City of Albuquerque

July 17, 2003

**RE: Silver Nugget Grading and Drainage Plan (K-22/D43)
Engineer's Stamp Dated July 2, 2003**

GRADING & DRAINAGE PLAN

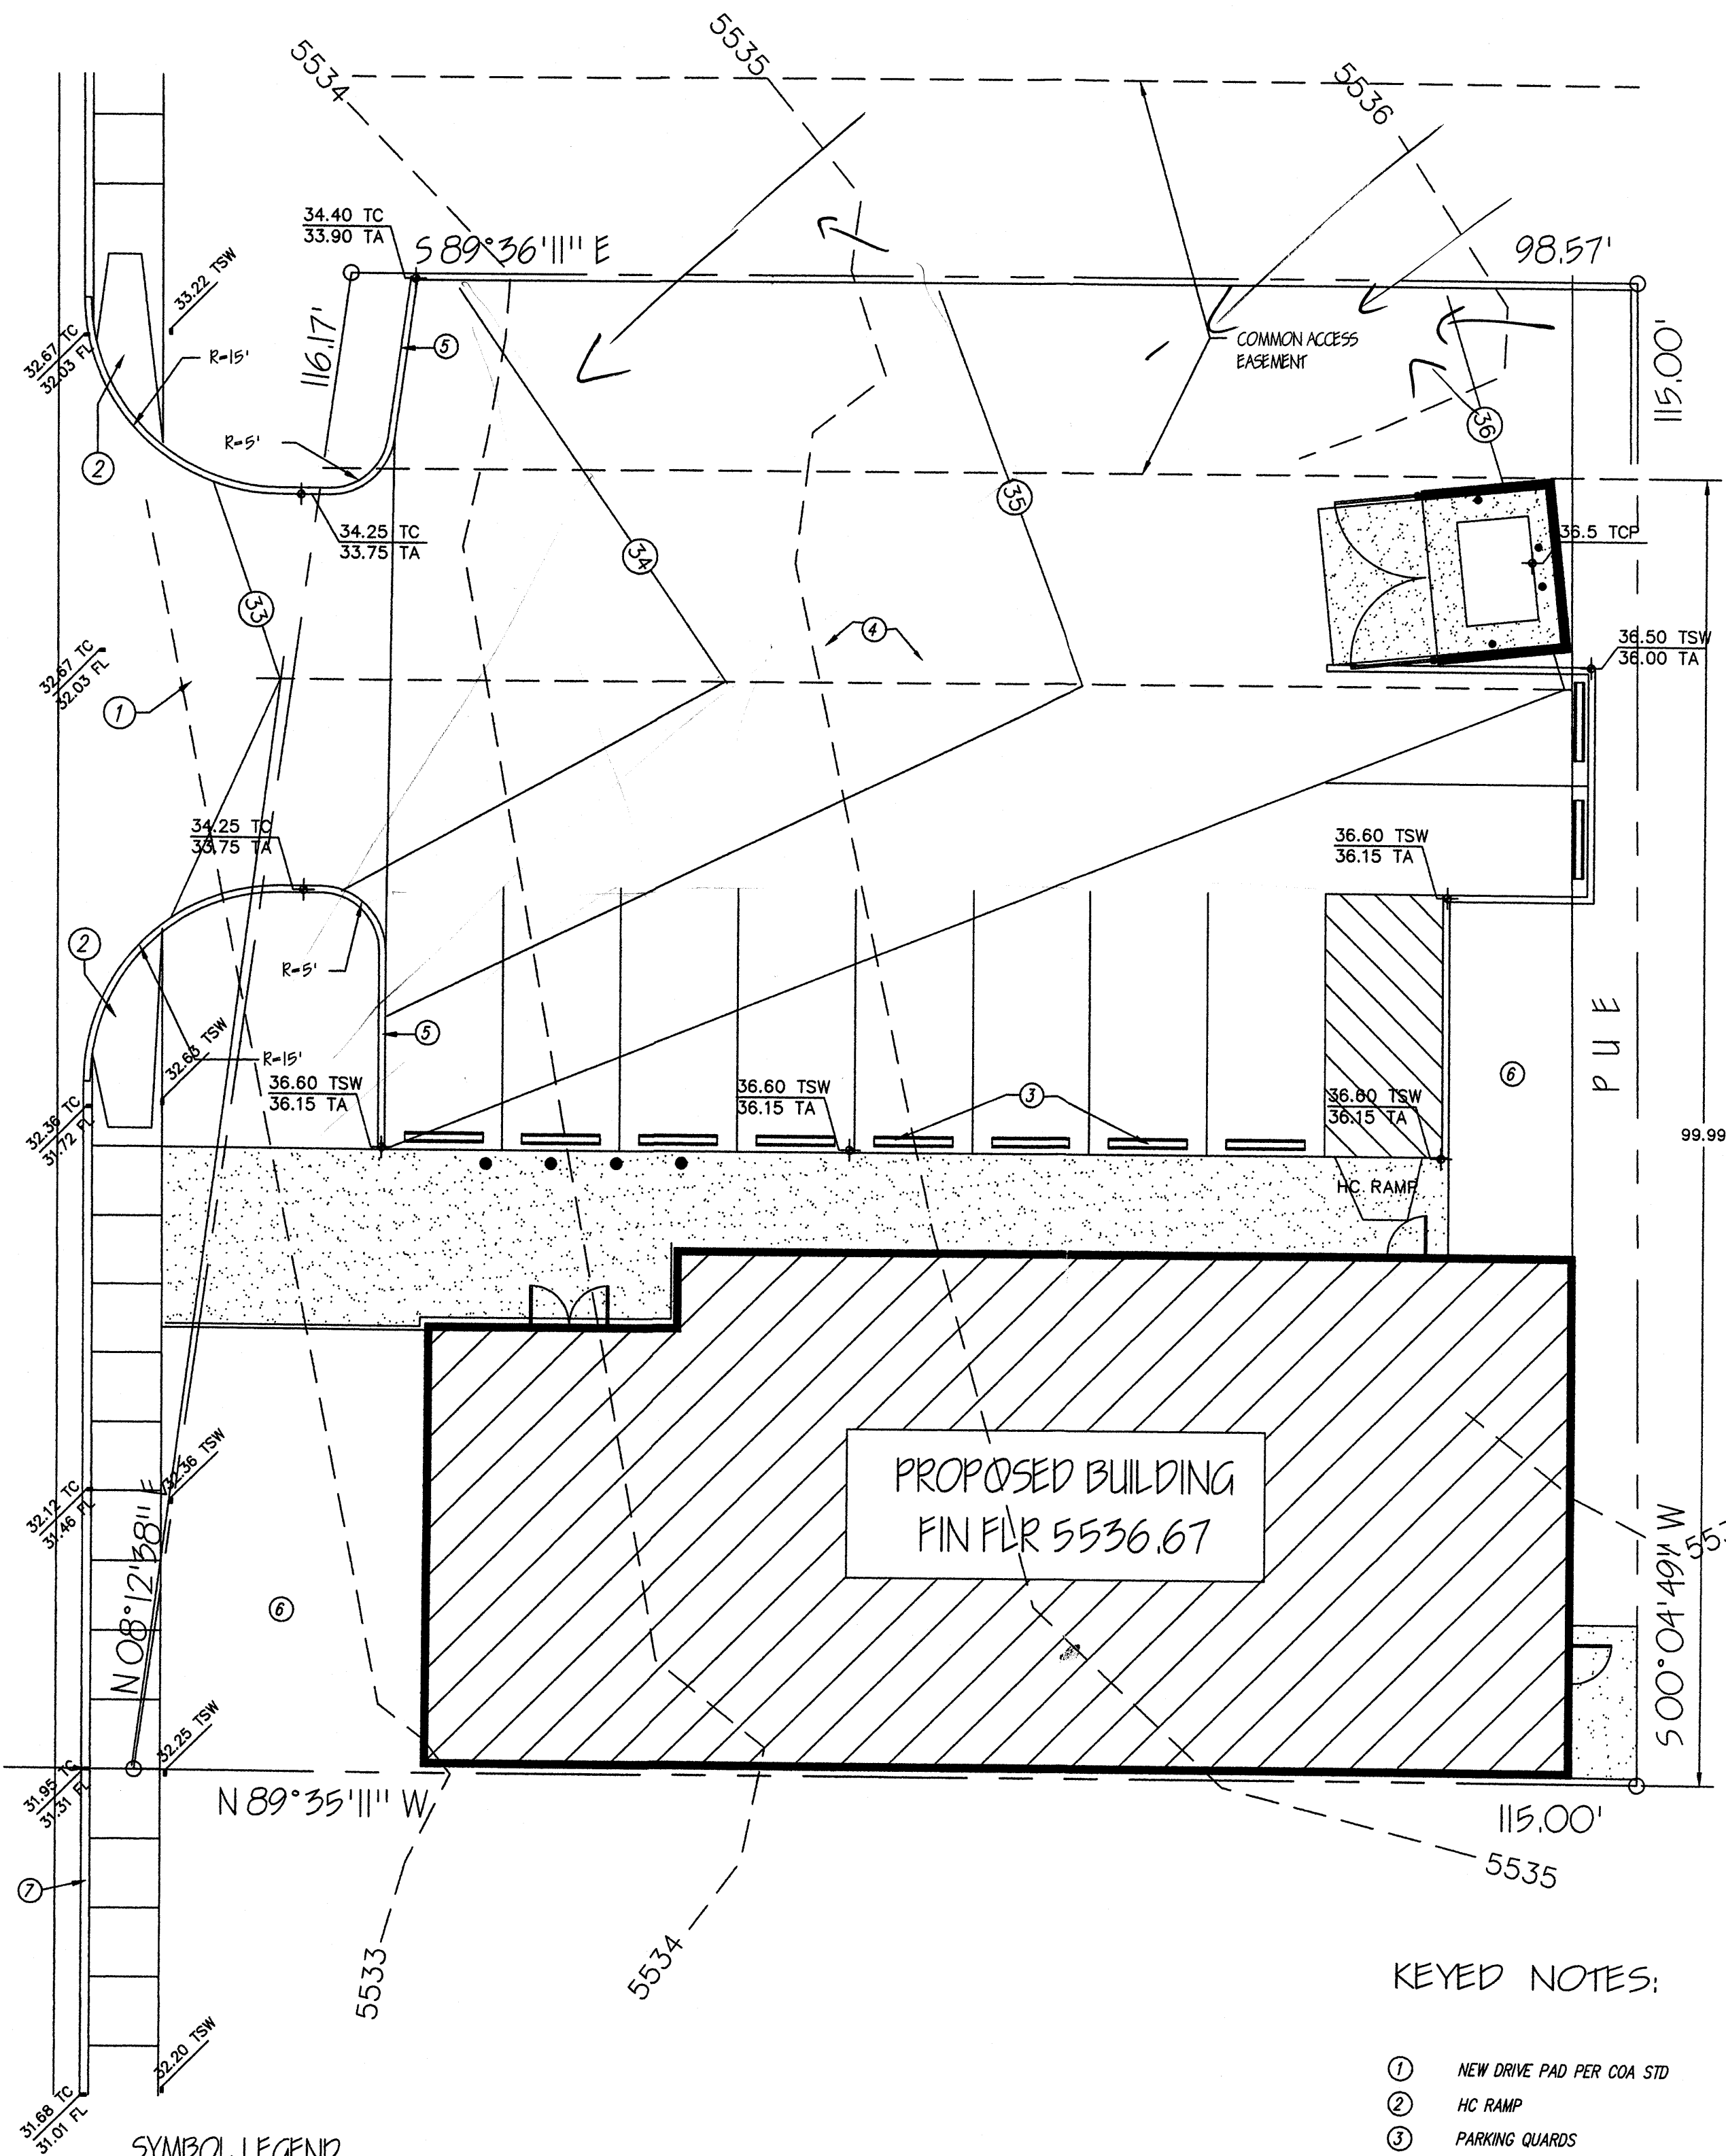
1. ***Is there any offsite flows? If so please quantify.***
Attached is a copy of the adjacent Garza & Garza Auto Body Inc. drainage plan, Which shows the flows being re-directed to the southwest of the site. Therefore no flows will enter the Silver Nugget site form the east. Juan Tabo borders the site to the west; no flows enter from the west. The existing building to the south drains their developed flows towards Juan Tabo.
2. ***Please show roof drains.***
Attached are the elevations of the building showing the location of the downspouts.
3. ***Will the common access easement need to be realigned due to the new drivepad location?***
The easement is not utilized for drainage or access. The existing Garza & Garza site does not use the easement for neither purpose.

1 SITE PLAN
C1.0 SCALE: 1" = 10'-0"

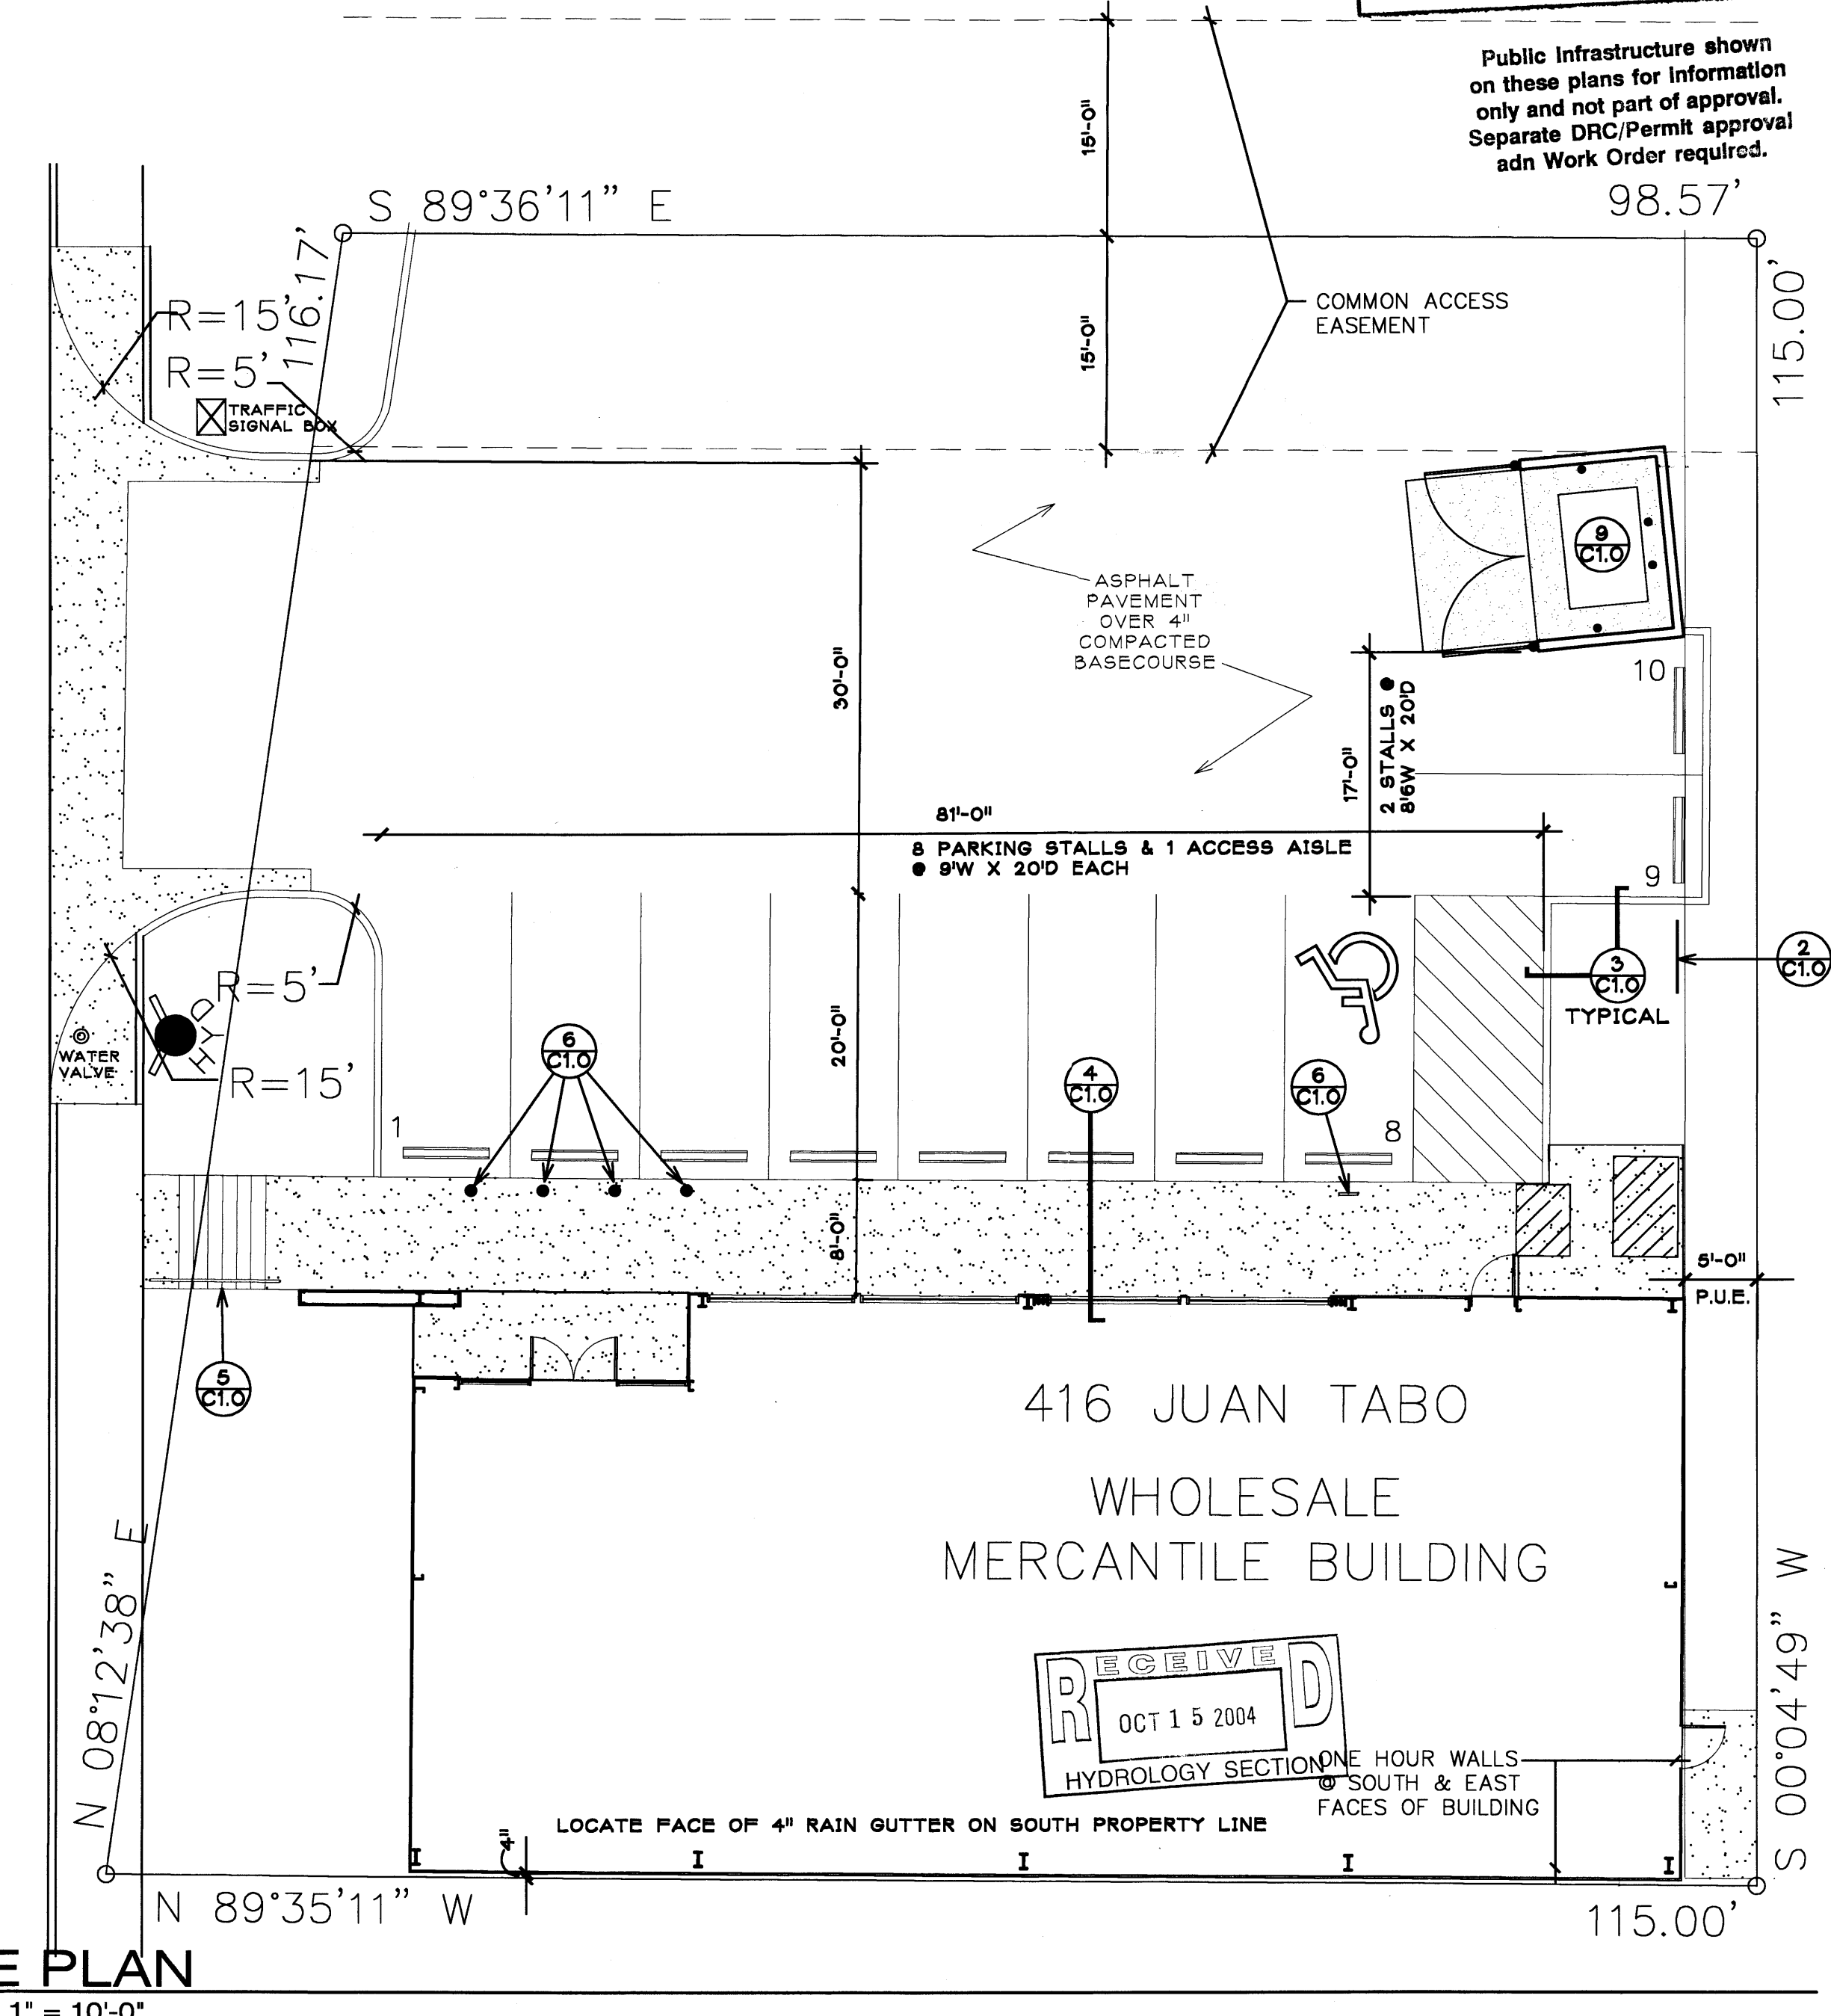
KATHY - ATTACHED IS A PLAN OF THE LOT 10-A EXISTING BUSINESS. IN ORDER TO GET A CITY REFUSE TRUCK ONTO THE LOT AND MEET CITY REQUIREMENTS WE NEED TO SHIFT THE DRIVE AD NORTH BY 18'-0".

NEED TO SHIFT DRIVE PAD TO NORTH
BY 18'-0", THIS LEAVES 42 FEET TO START OF
ACCESS CONTROL FENCE.
